**SEAS DEADLINE 6 RESPONSE to APPLICANTS's SUBMISSIONS**  
**SINCE DEADLINE 5, ISH3, Action Points and ExQ3**  
**LANDSCAPE & VISUAL and CULTURAL HERITAGE**

**PINS Ref:** EN020026  
**DEADLINE 6:** APRIL 13, 2026

**RE: SEAS Response to Applicant's Submissions since Deadline 5, ISH3, Action Points and ExQ3 – Landscape & Visual and Cultural Heritage**

# EN020026 SEA LINK DCO – DL6: RESPONSE BY NICHOLAS BRIDGES

Figure 12. Sea Link EN020026-000339-6.4.2.1 ES Figures Suffolk Landscape and Visual Part 1 of 7, page 14
 REPRESENTATIVE VIEWPOINT LOCATIONS AND SCREENED ZONE OF THEORETICAL VISIBILITY - SEA LINK AND FRISTON SCENARIO 1

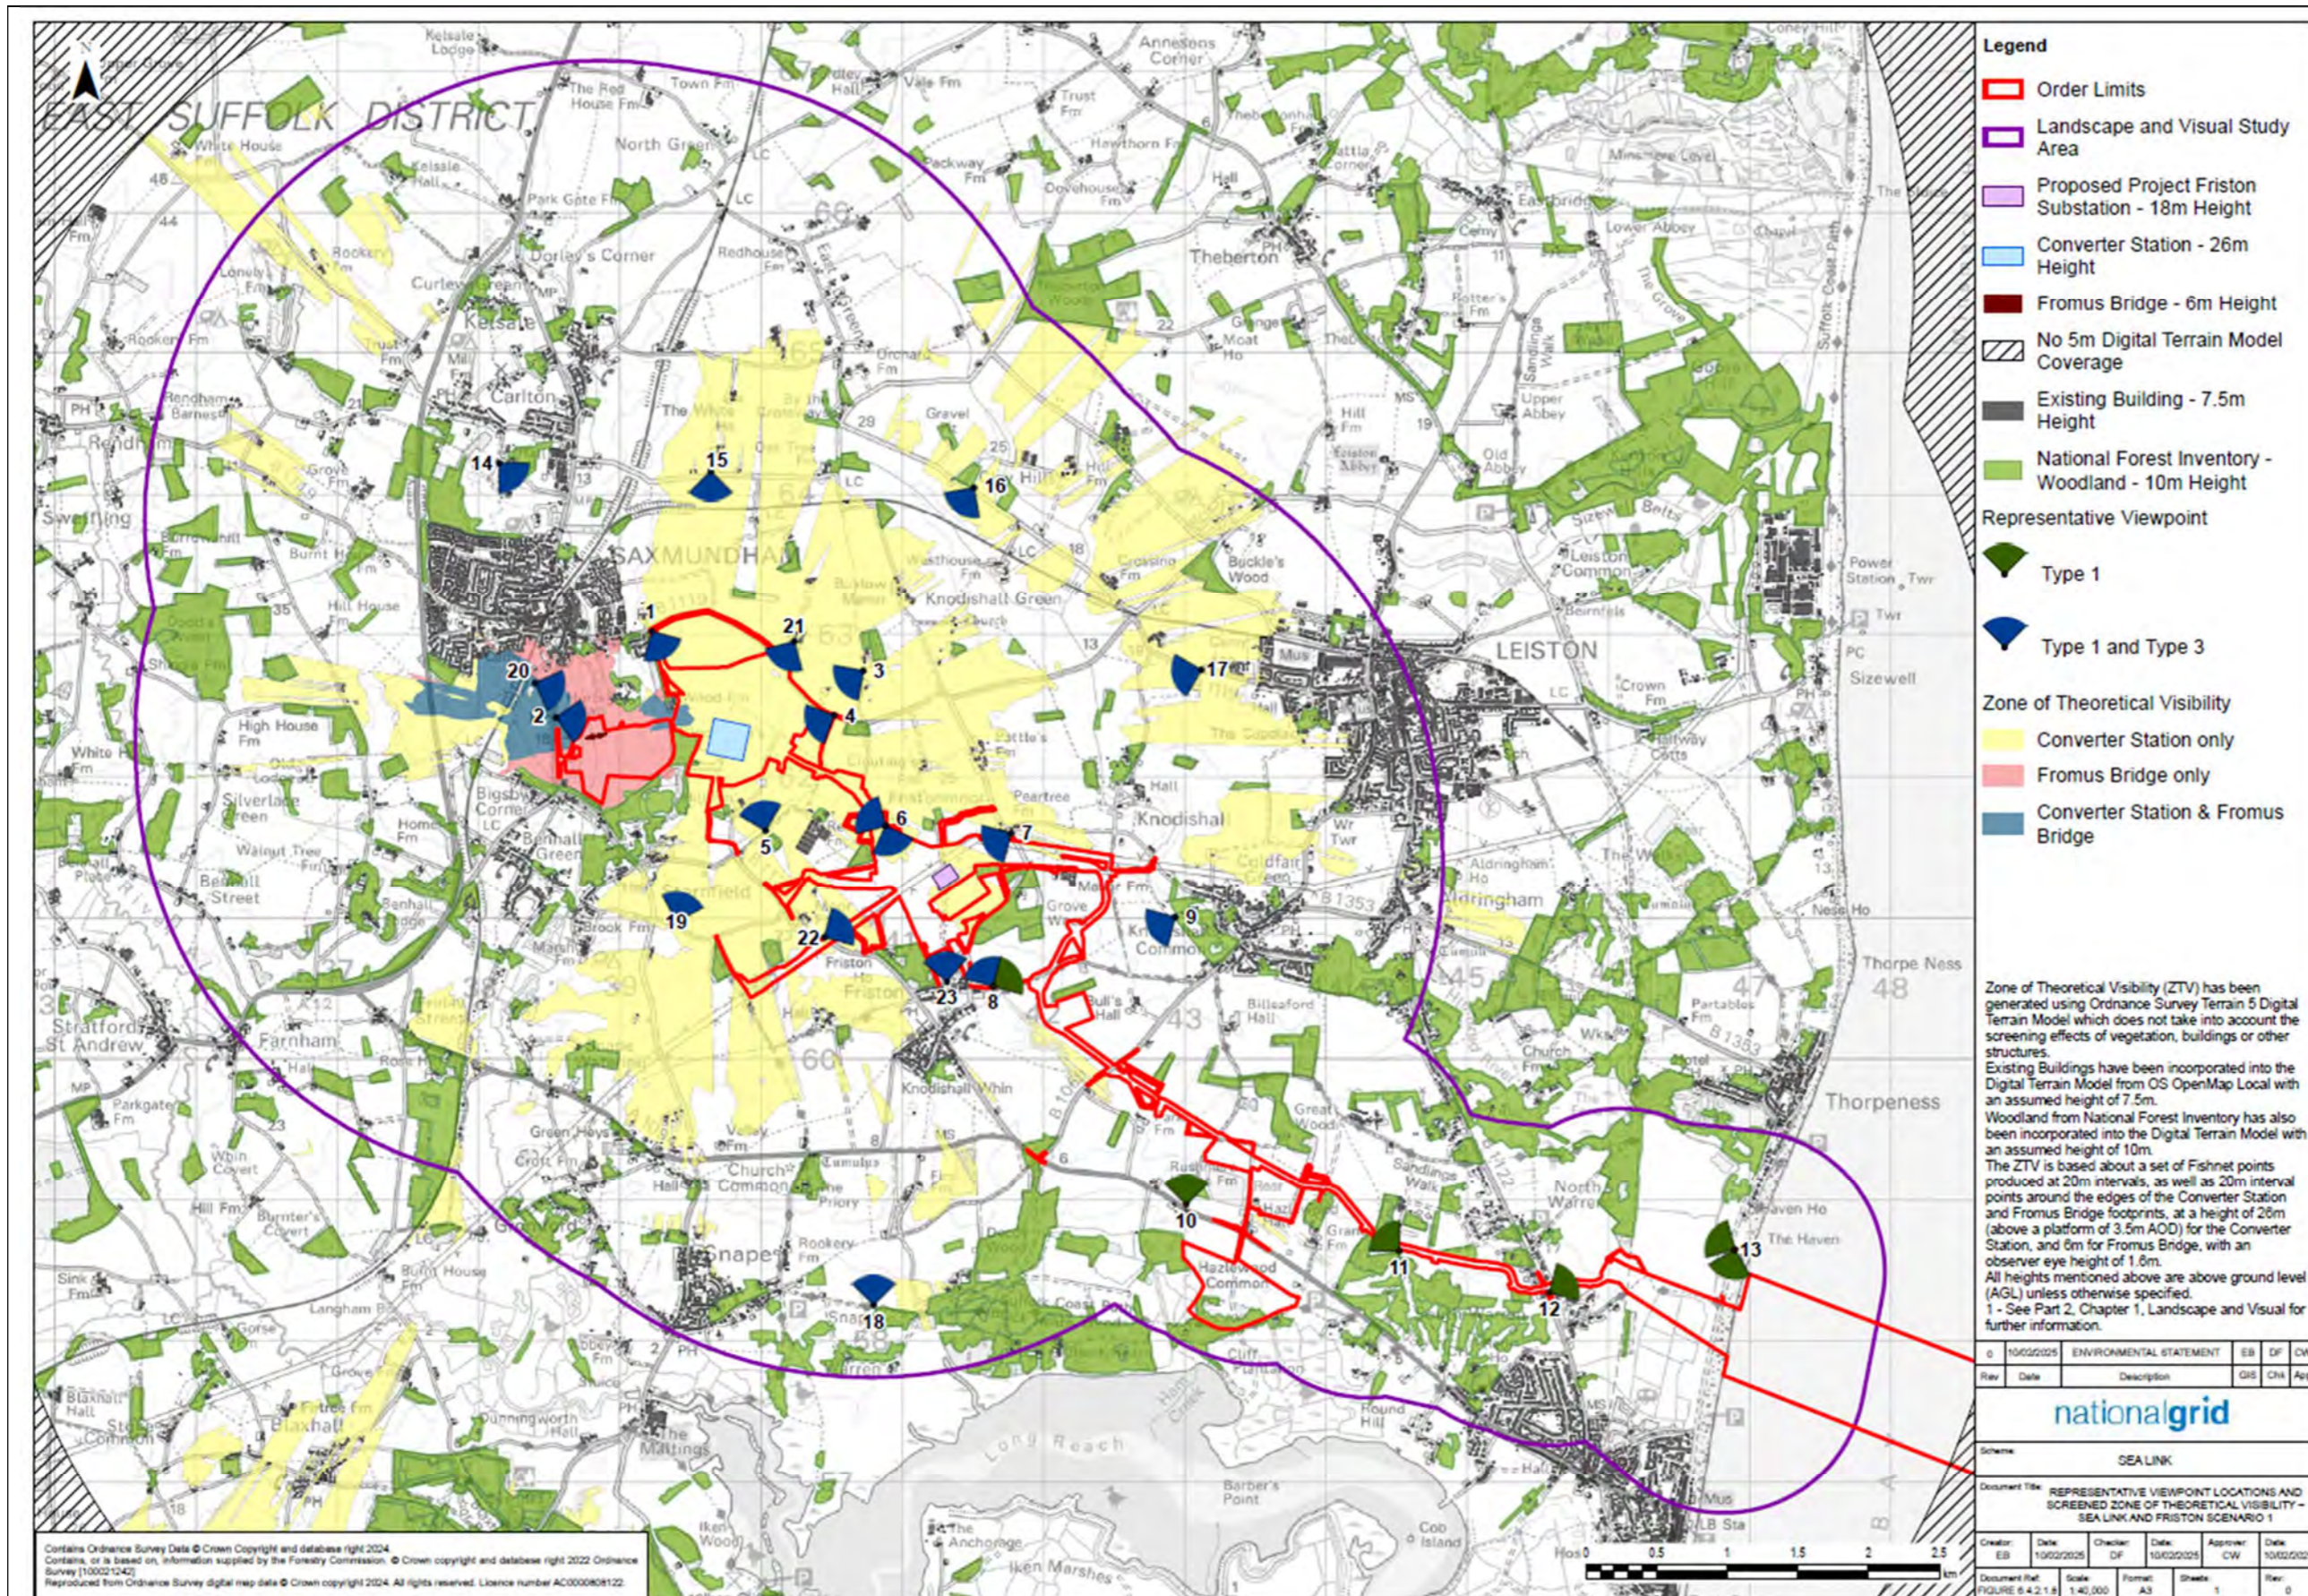
2.10. The 'shadow' patterns illustrate the 'shading' effects of woodland and buildings. The ZTV plans of the same proposed volumetric parameters (**Figures 12 to 17** below) show far less visibility than its PEIR ZTV plans. The accompanying textual details of the model's constraints are exactly the same (see the schedule below).

2.11. The **first question** is: why are the PEIR and DCO plans so completely different? Were the heights in the model changed? Were the shadowing criteria altered? Which is correct? If the DCO is correct, were the EA1N and EA2 ZTVs incorrect? These are simple technical points which can be explained easily.

- 3.1. The submitted DCO ZTV plans should be reviewed for their accuracy.
- 3.2. If they are correct, the applicant must explain why the PEIR was so different
